From: [REDACTED]
To: [MU1](#)
Subject: 2021/1090 Consultation response Parks Services
Date: 21 December 2023 11:22:43
Attachments: [image001.png](#)
[image002.png](#)
[image003.png](#)
[image004.png](#)
[image005.png](#)
[image006.png](#)
[image007.png](#)
[image008.png](#)
[image009.png](#)
[image010.png](#)
[image011.png](#)
[image012.png](#)
[20211090 Landscape Masterplan Rev. 09 \(6MB\).pdf](#)

Subject: 2023 12 20 2021/1090 Landscape masterplan MU1

To confirm our discussion and my thoughts on the proposed play provision within the MU1 development.

5.6 COMPLIANCE: LAPS

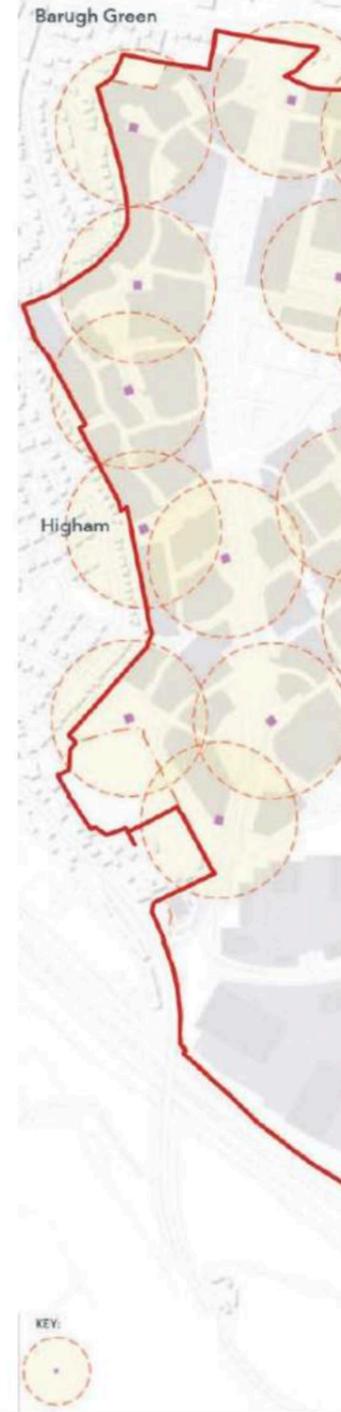
1. The development to the west the new road from Barugh Gren Rd, is deficient in access to play provision. I would recommend a LEAP standard play space within this area to serve those residents.

2. The close proximity of the LEAP & NEAP spaces to the east of the main entrance road that backs on to Redbrook estate- two separate sites are not really required. A NEAP play zone with a min of 8 different items of play equipment plus some youth provision eg MUGA - would serve a radius of 1200m, and be sufficient to serve that north eastern housing area.

3. The 3 play zones towards the southern end of the development are confusing. 2 NEAPs and a LEAP within close proximity. Again a quality NEAP standard play zone in this area would serve that lower development., I understand that the active travel rout near that site is pedestrian /cycle only, so there's no issues with severance by vehicular road ways.

4. The LEAP to the south is sufficient to serve that community.
5. I'm assuming that all the green spaces/green ways will be accessible from the existing housing surrounding the MU1 sites, if this is not the case then I'd suggest provision is made to do so.
